PLANNING AMENDMENT

Application No. H02/1434/00.

Stable Building

Dear Sir,
PROPOSED STABLE. NENE TERRACE. CROWLAND.

SITE LOCATION PLAN

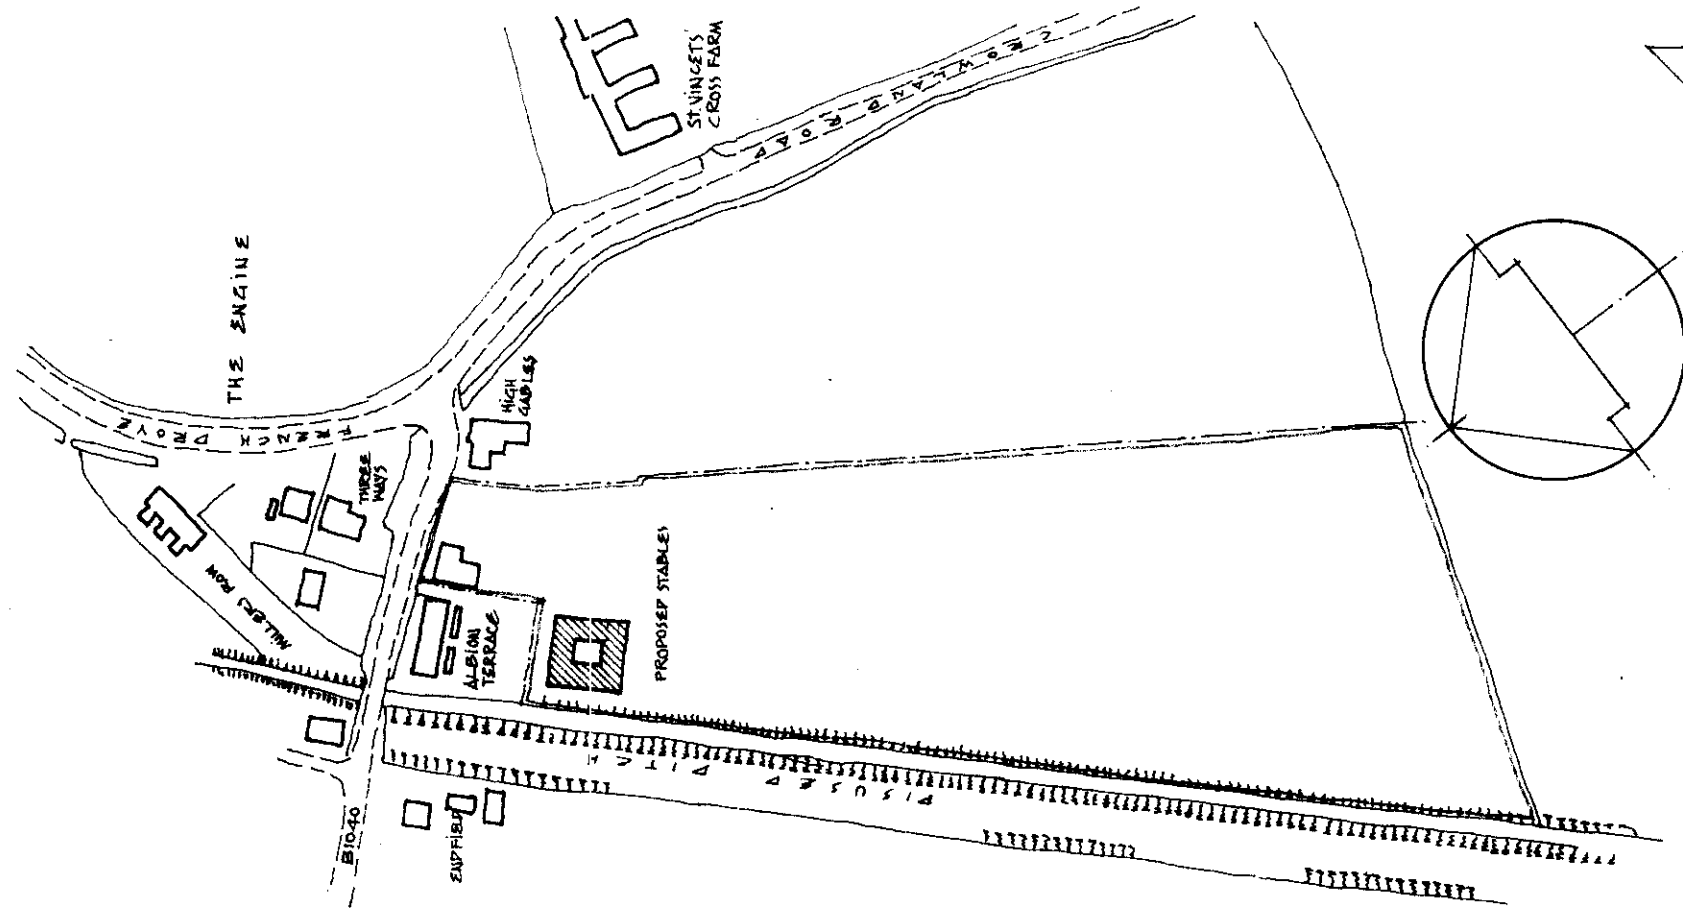
Revised siting
of stables

Further to recent discussions concerning the above project; I am pleased to confirm that my client Mr. R. Godman, and your Environmental Unit officer Mr. J. Chapman, have agreed to site the proposed stables 25 metres from the boundary of his neighbouring property.

My enclosed drawings have been revised to illustrate this.
